National Trust objection relating to SSD-31179510 Gregory Place Build-to-Rent

The National Trust of Australia (NSW) expresses its strong objections to the proposal for the construction of three separate, large scale buildings with 483 dwellings within the site located at 2A Gregory Place, Harris Park.

Figure.161 Elevation illustrating built form fronting Hambledon Cottage

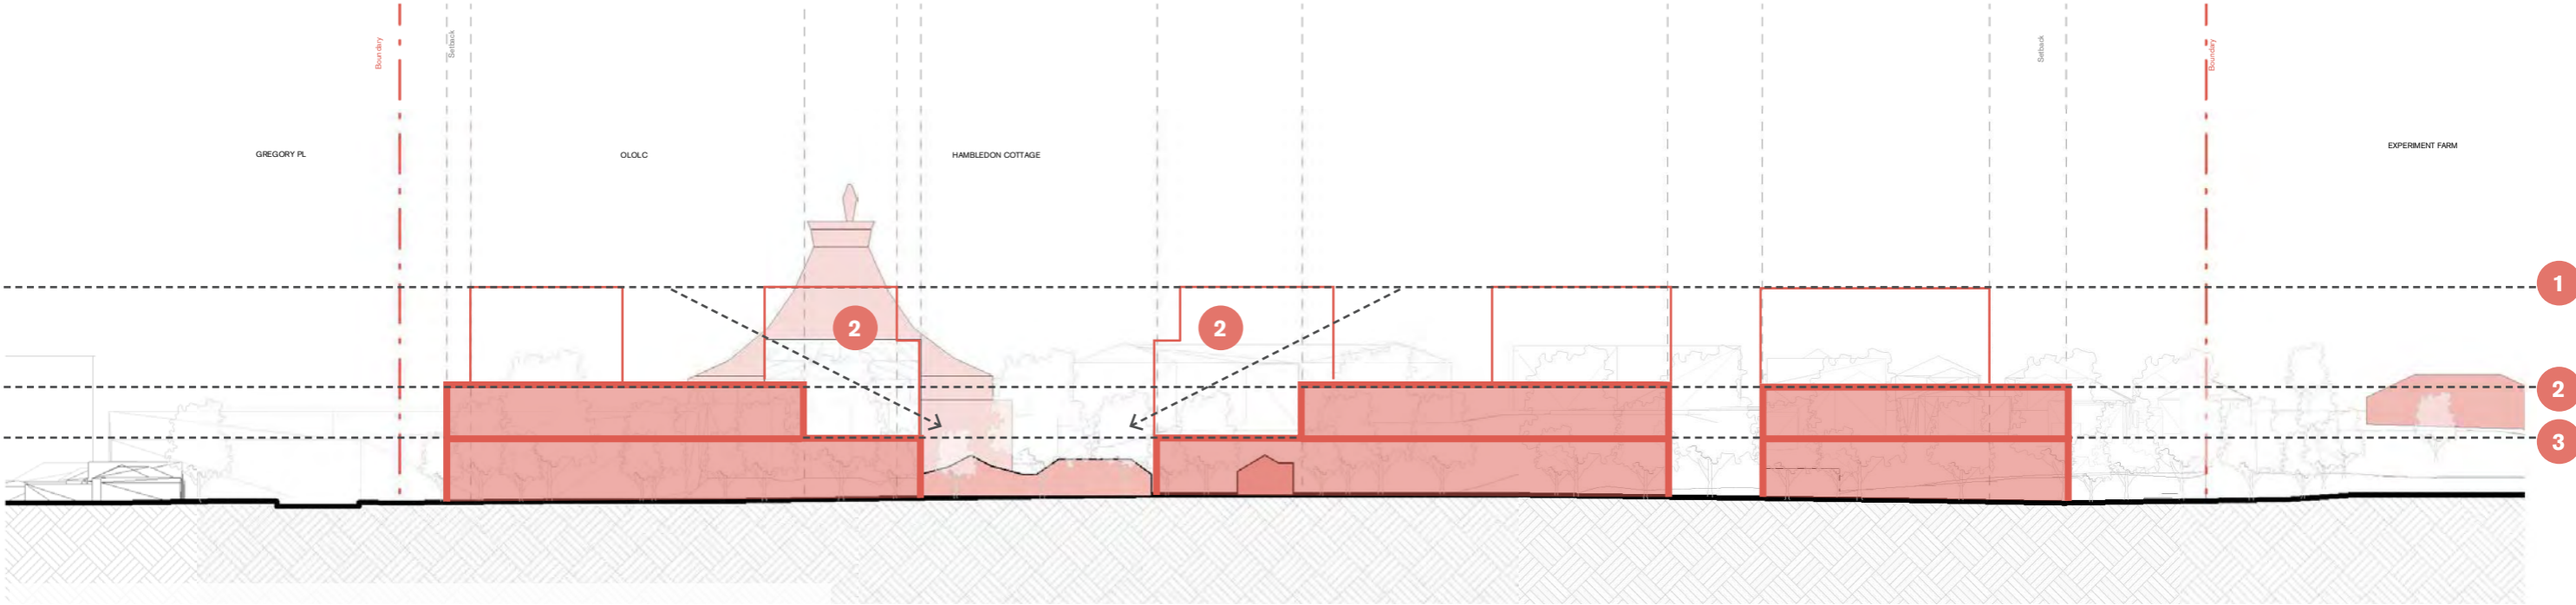
- The proposal will completely destroy the historic setting of Hambledon Cottage, removing its ability to be read with a blue sky background;
- The proposal does not consider the impact on the larger setting of Hambledon Cottage, Experiment Farm and Elizabeth Farm;

We totally dispute the claim in the Visual Impact Assessment (p.15) that the visual impact on Hambledon Cottage is Moderate/Low, and the argument that “Hambledon Cottage is subservient to the existing vegetation of the SHR.” Hambledon Cottage, Elizabeth Farm and Experiment Farm are not “subservient” to vegetation. They are (individually and collectively) a rare grouping of colonial landscapes, including houses, trees and gardens, that together form a distinctive landscape. The tall Hoop and Bunya Pines are there *because* of Hambledon Cottage, not the other way around.

Figure.165 Elevation illustrating built form fronting Experiment Farm reserve

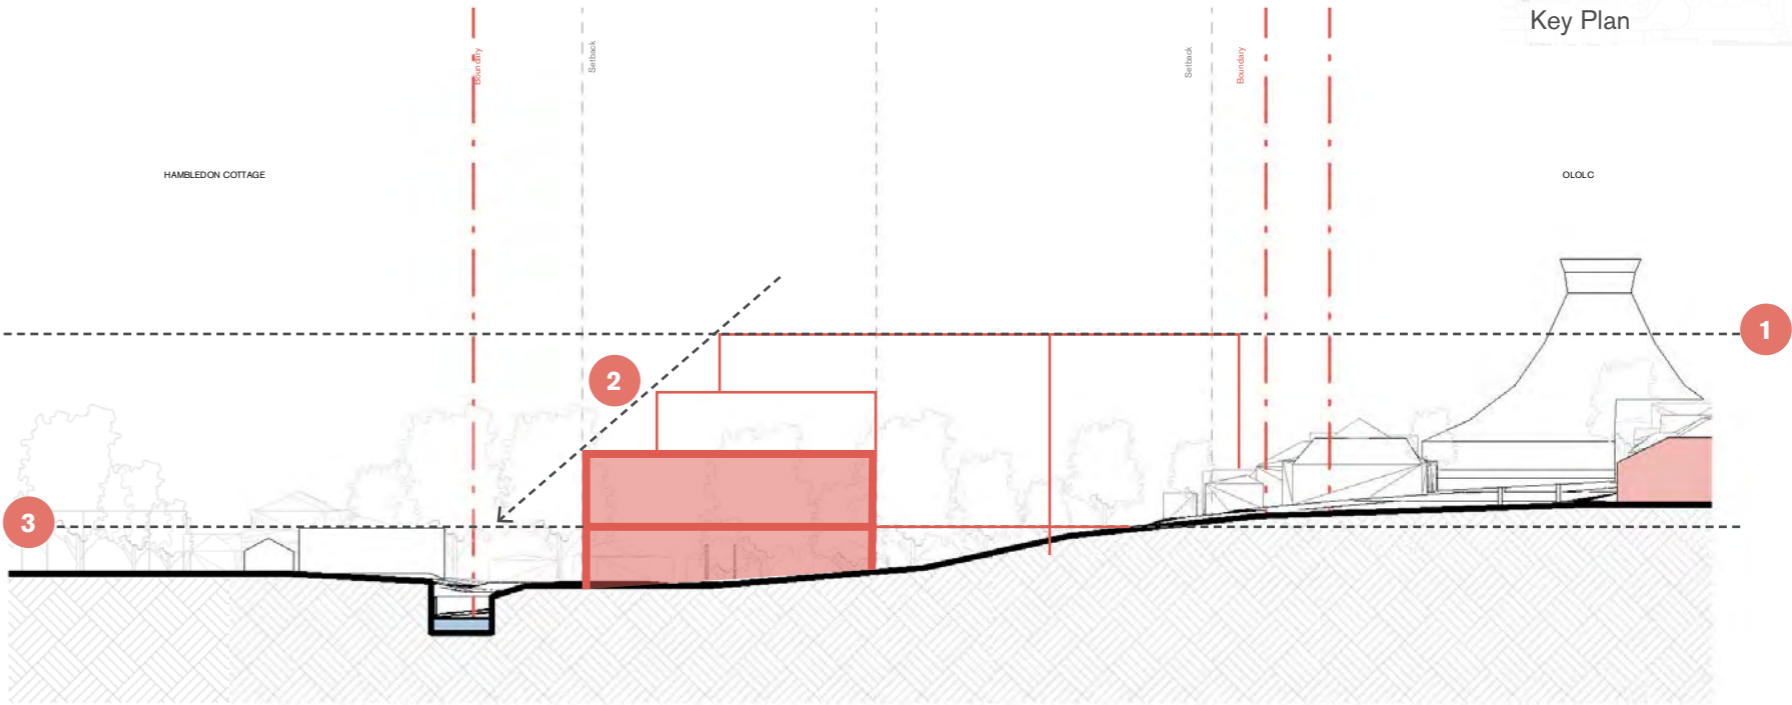
- The proposal does not align with any planning controls for the site and will fundamentally change the predominant low-rise character of Harris Park;
- The proposal will impact the views and setting from the National Trust's property Experiment Farm and the Sydney Living Museum Property Elizabeth Farm.

This is a core National Trust objection to the current proposal – that the proposed project amplifies the impact of intrusive developments and directly opposes the active work of government and community to protect and enhance the setting and views of these three places.
